From: Gomez, Angela J.
Sent: Tuesday, August 04, 2020 2:02 PM
To: Gomez, Angela J.
Subject: FW: [#2020013] Wintergreen Apartments DRB questions (PR-2020-004030)

From: Richard Stevenson [mailto:rstevenson@tierrawestllc.com]
Sent: Tuesday, August 04, 2020 1:55 PM
To: Marsha Kearney
Cc: p crump; Ron Bohannan; rick@rba81.com; gnh5976@gmail.com; 1garciagang@gmail.com; mdmiraba@msn.com; meganfitz@live.com; bcreel@msn.com; frandimarco@msn.com; cfmirabal@gmail.com; ruffkat@yahoo.com; david.m.lopez@msn.com; garnand_lu@yahoo.com; kmcvey124@comcast.net; tjmurieta@msn.com; nenaperkin@gmail.com; avalgman12@gmail.com; scott.templeton@comcast.net; chavezdyx4@yahoo.com; mccormackdj@comcast.net; erin.coffman@yahoo.com; huerta.loretta58@gmail.com; gayle.binkley@me.com; marshakearney@gmail.com; nauticalhutch@gmail.com; miladybutler@yahoo.com; rfasel@fed.net; Gomez, Angela J.; Wolfenbarger, Jeanne; Gould, Maggie S.
Subject: RE: [#2020013] Wintergreen Apartments DRB questions (PR-2020-004030)

The intent of this email is to provide responses to the questions raised by neighbors at the DRB hearing on July 22nd 2020, in regards to the proposed Wintergreen Apartment project City project number PR-2020-00

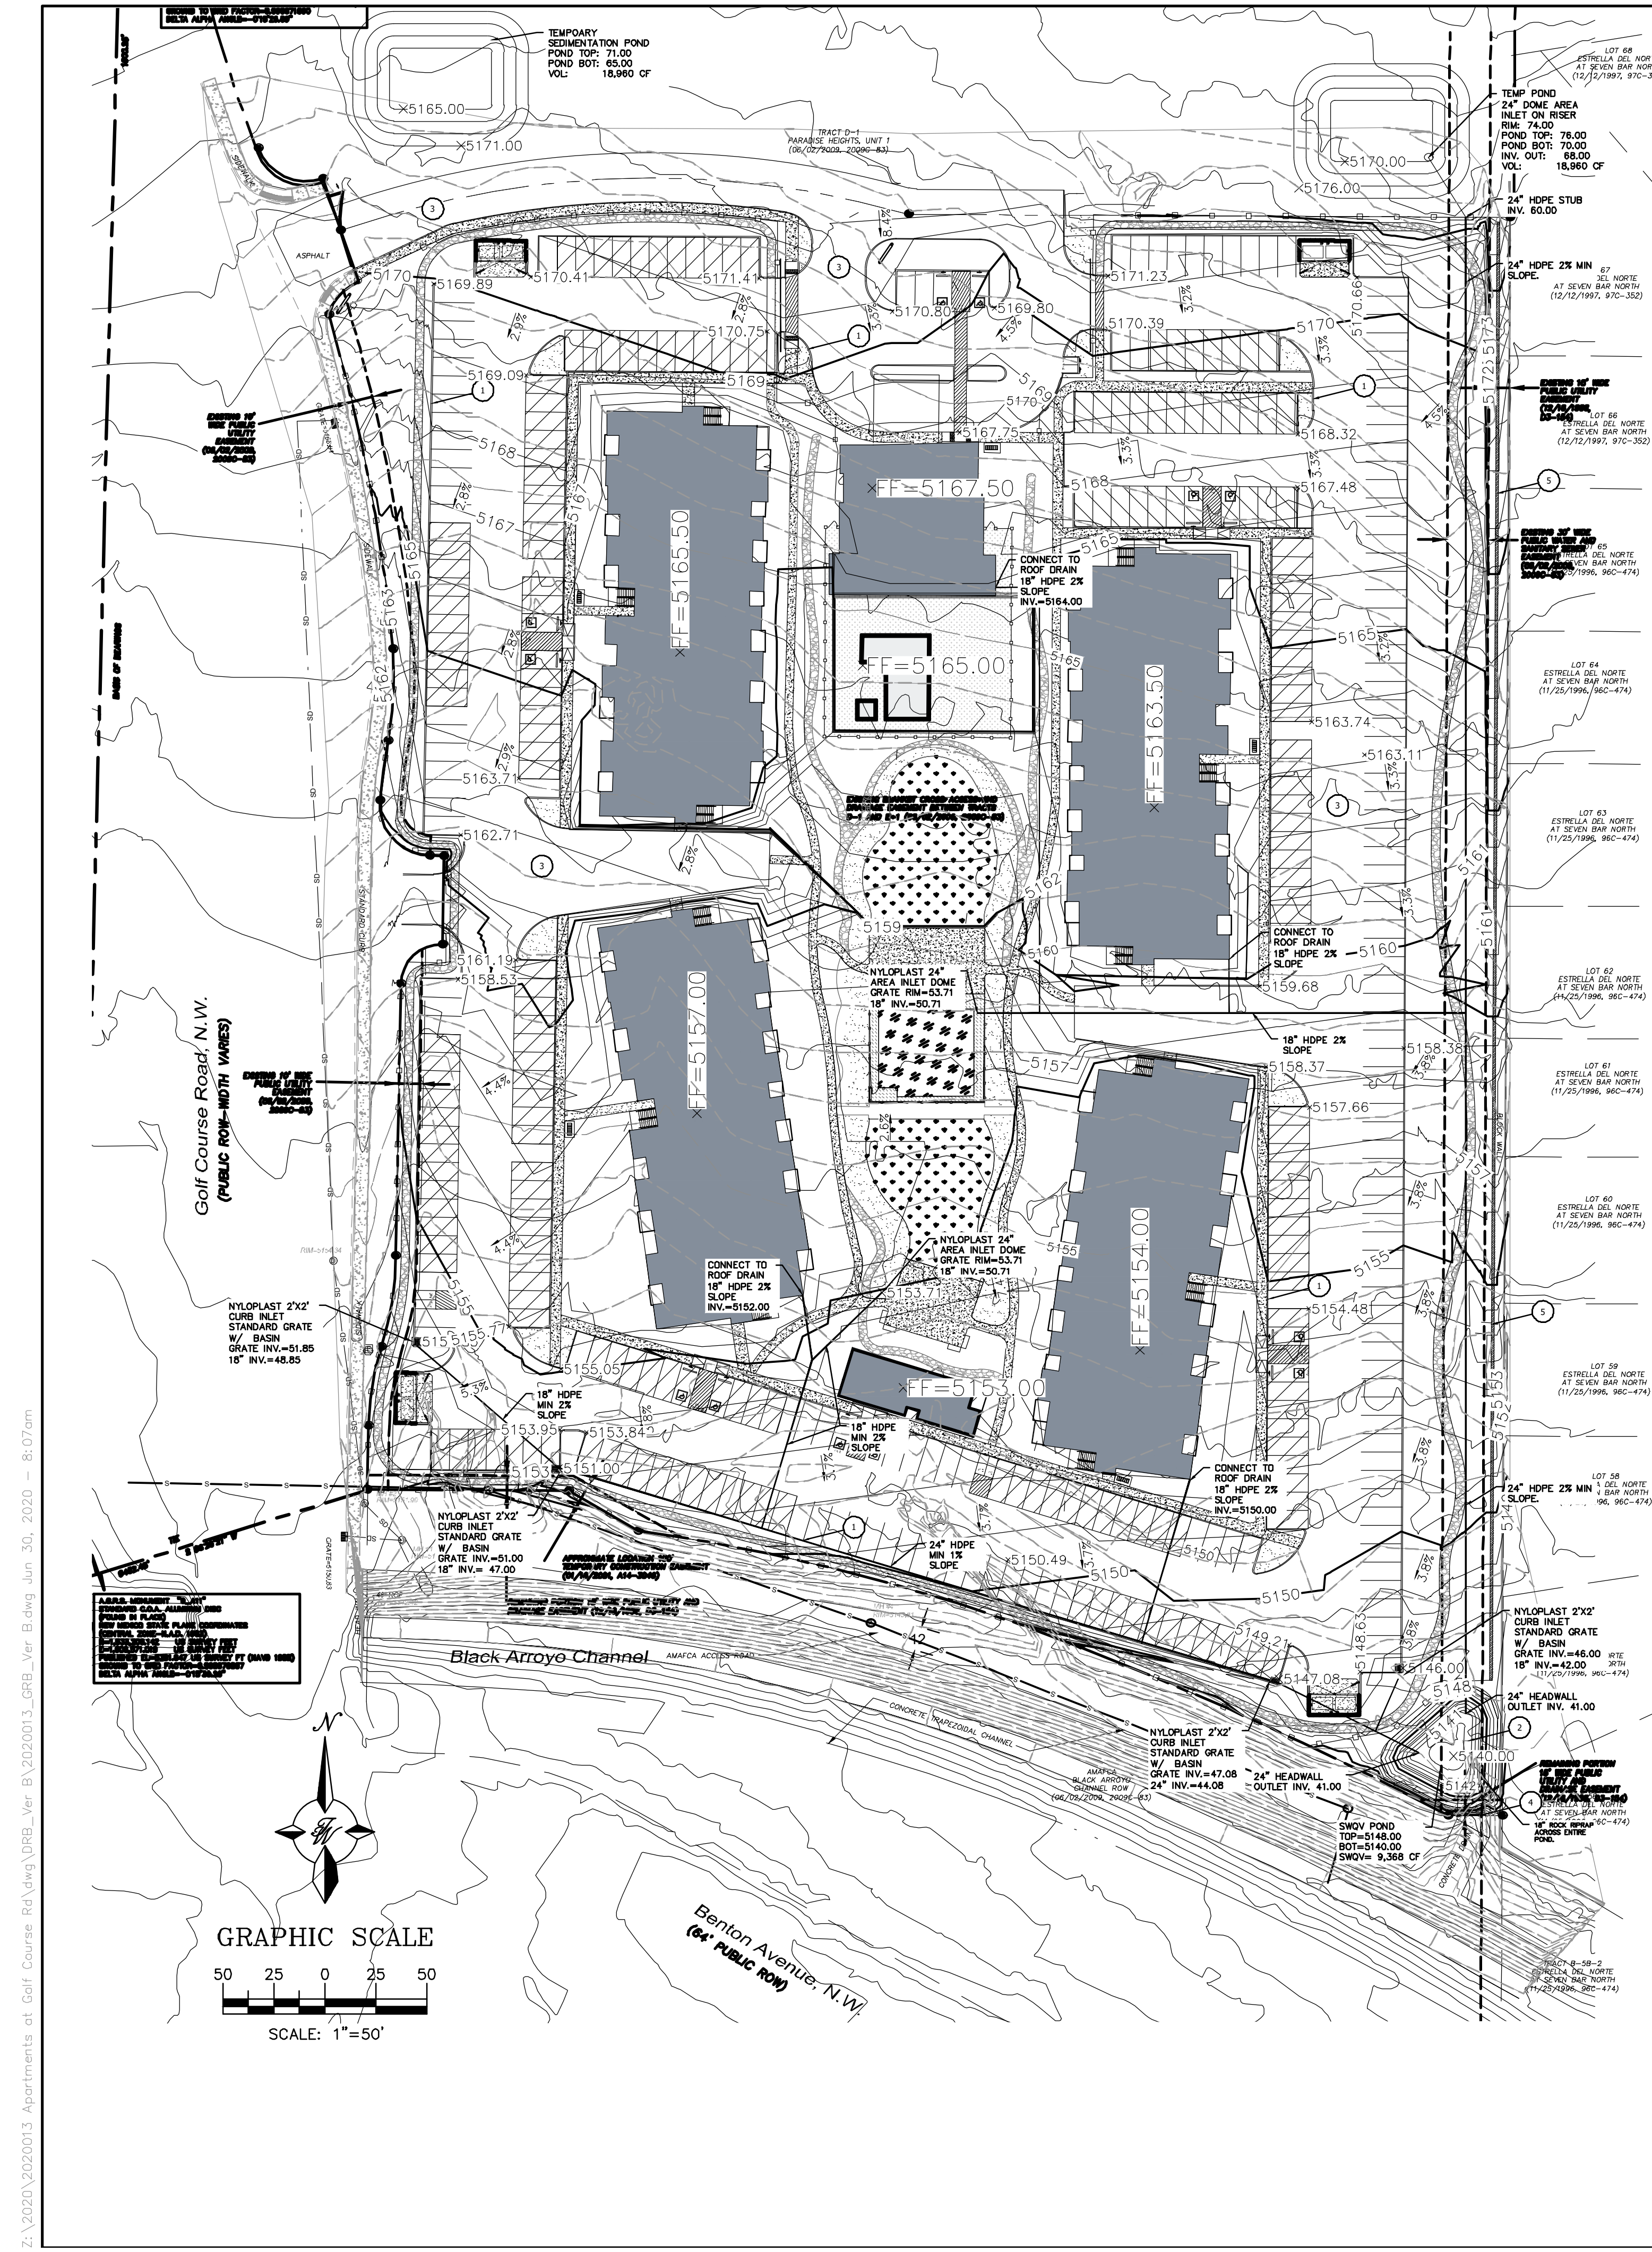
- We have requested sound barriers, Line of sight barriers, fencing barriers, landscape barriers, lighting barriers.

- We requested a sound and visibility wall at least 8 feet along the East end of the property boundary.

- We have requested that the recreational walking trail adjacent our properties be removed.

Response: A 6-ft CMU block wall is proposed to be installed 5-ft offset the property boundary.

Response: Where feasible we are proposing 2-ft earth bench to elevate the 6-ft wall to include the effective height.

Response: The walking trail has been shifted to the west further away from the east property line but remains for the residents to utilize for recreational exercise.

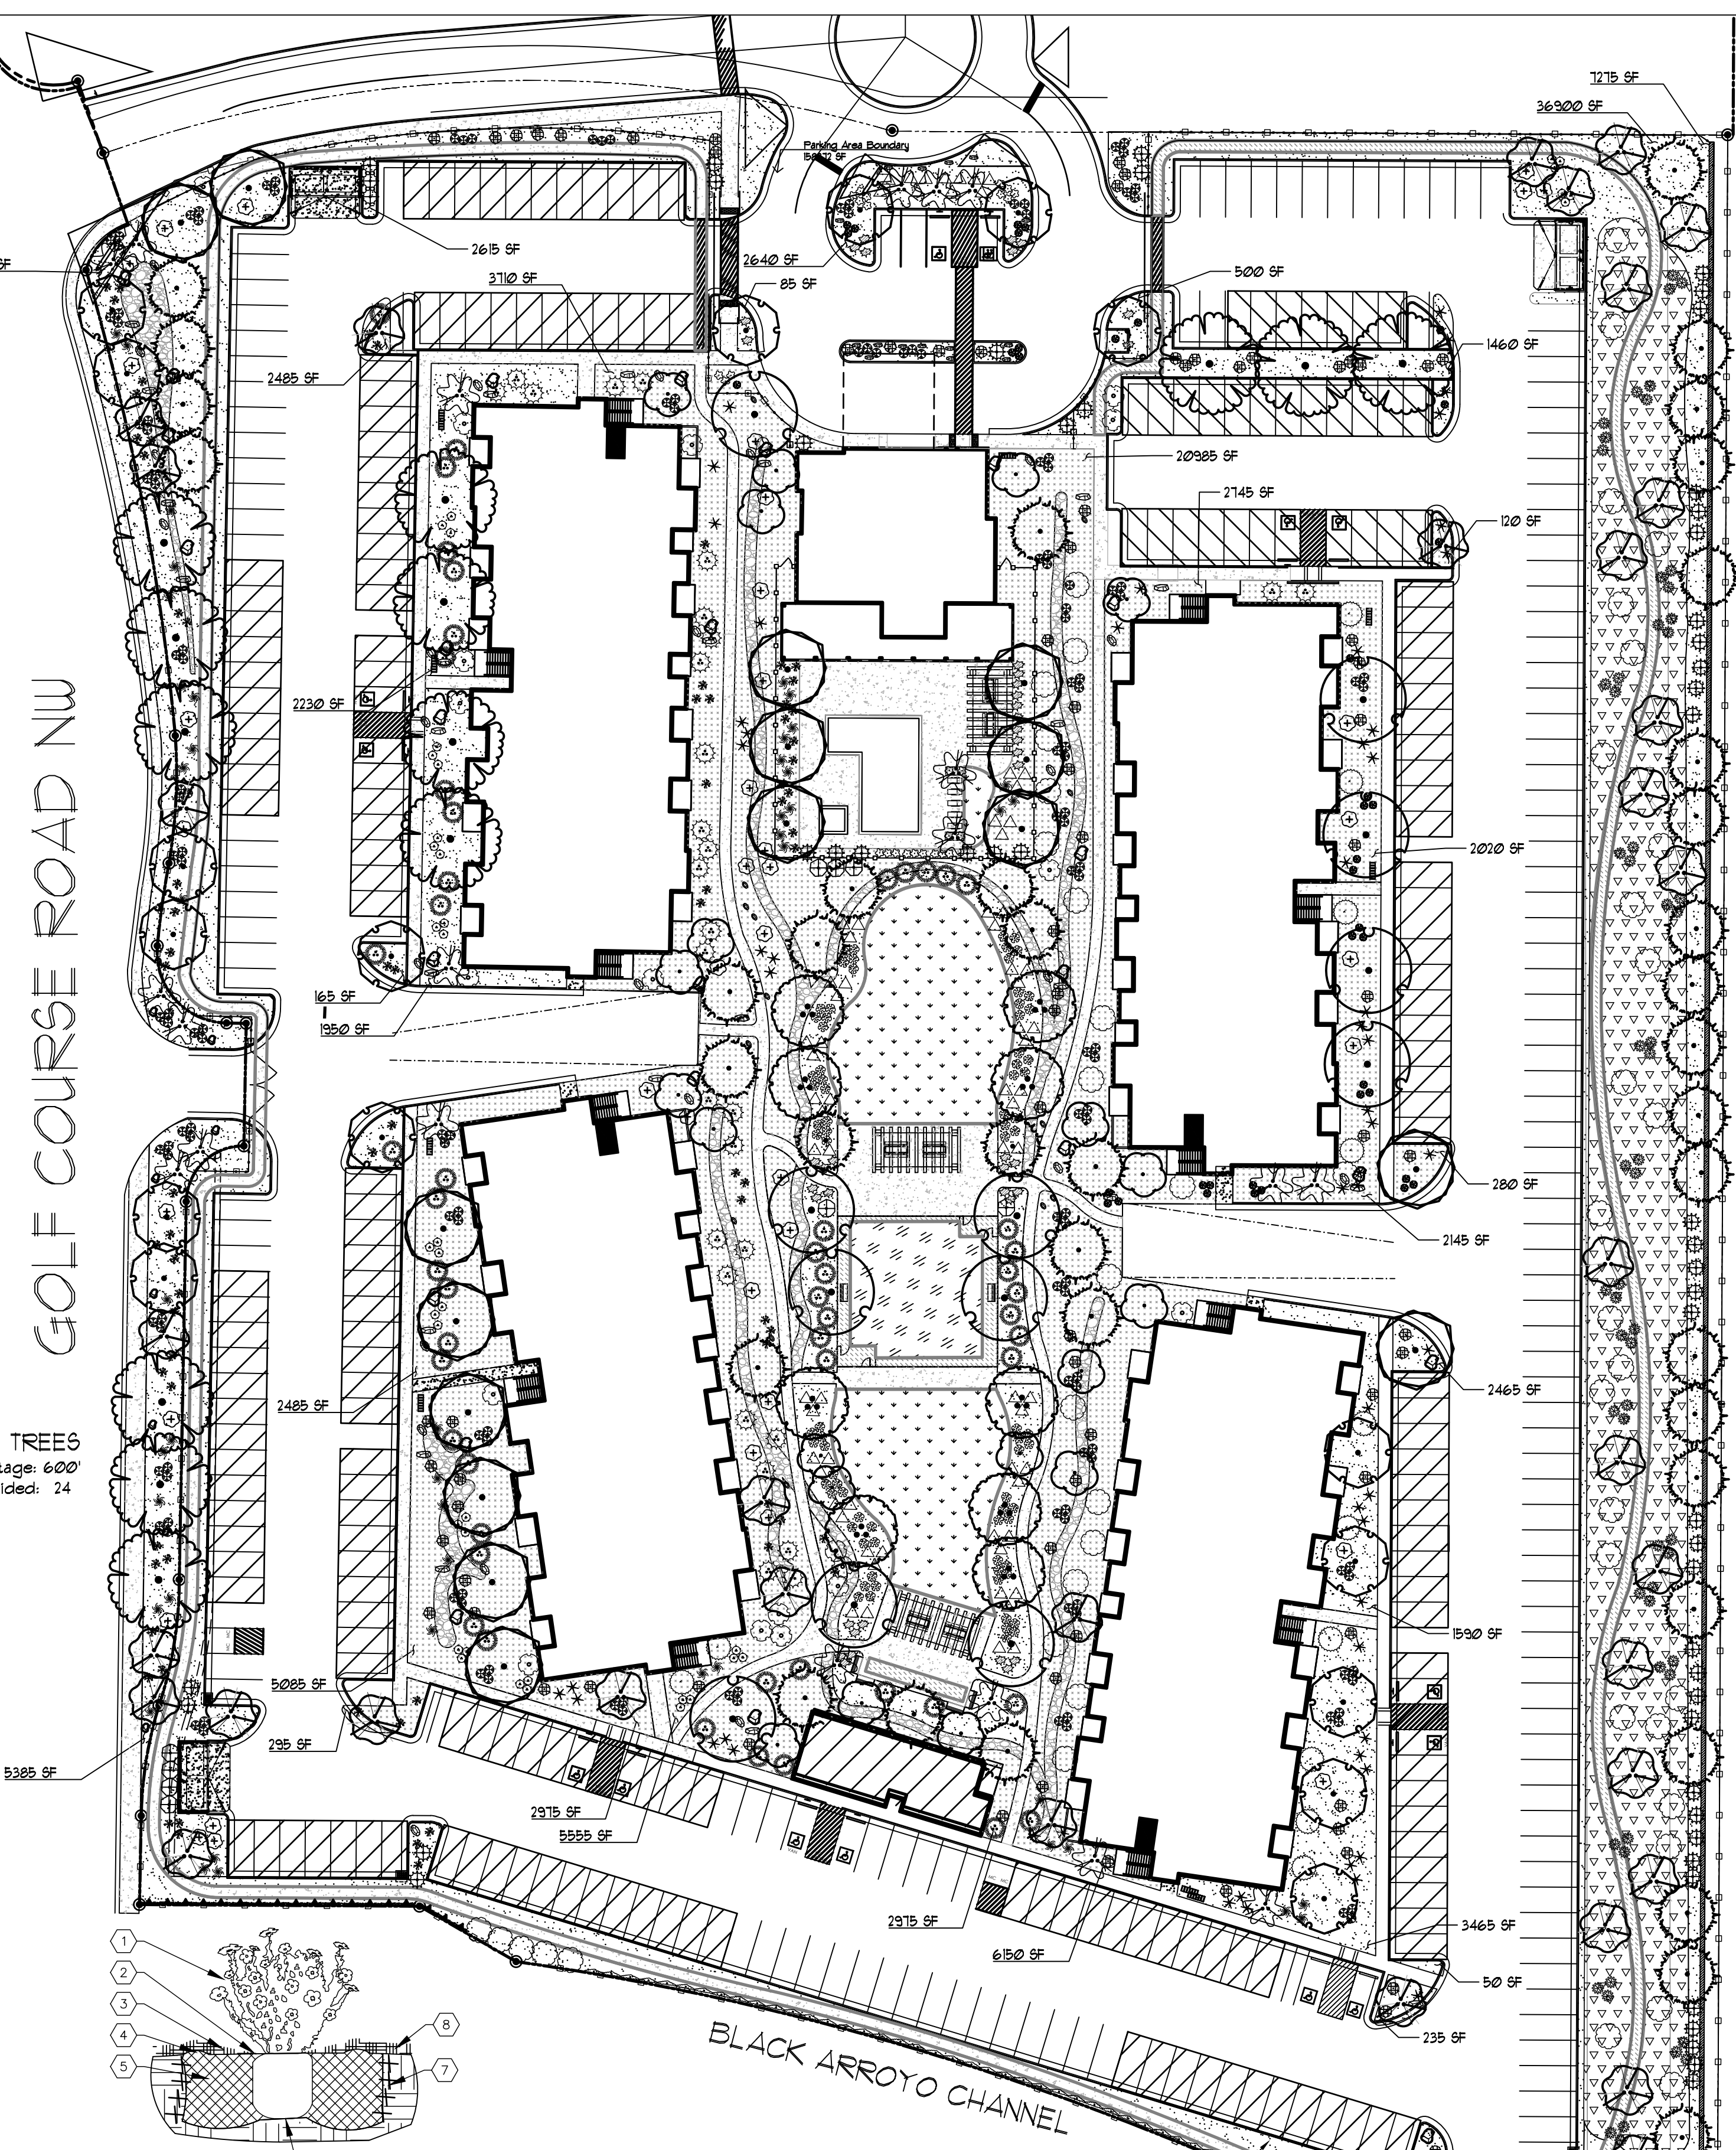
- We also would like the landscape plan to include more mature trees, to protect immediate privacy. The current plan has at least 10-year maturity

- We would like plants that do not affect allergies. Juniper plants are a major contributor to allergies.

Response: 6-ft plus high trees will be installed at install for the Austrian Pine species, Chinese Juniper planted as 5 gal shrubs, the other tree species shall have a 2-inch plus caliper.

Response: The two types of evergreens are selected for the eastern edge of the landscape:

- Austrian Pines / *Pinus nigra*. Uncommon tree allergen, minimal needle drop with regular irrigation.
 - Chinese Juniper / *Juniperus chinensis* – ‘Spartan’ (narrow) variety, planted as 5 gal shrubs. FEMALE TREES ONLY per compliance with City Aeroallergen Ordinance.
 - The city tracks and puts out daily air quality pollen counts. Junipers, a common allergen, are included. Pines, an uncommon allergen, are not included.
- We want Trash Bins moved away from the East side of the development, away from homeowners’ properties.
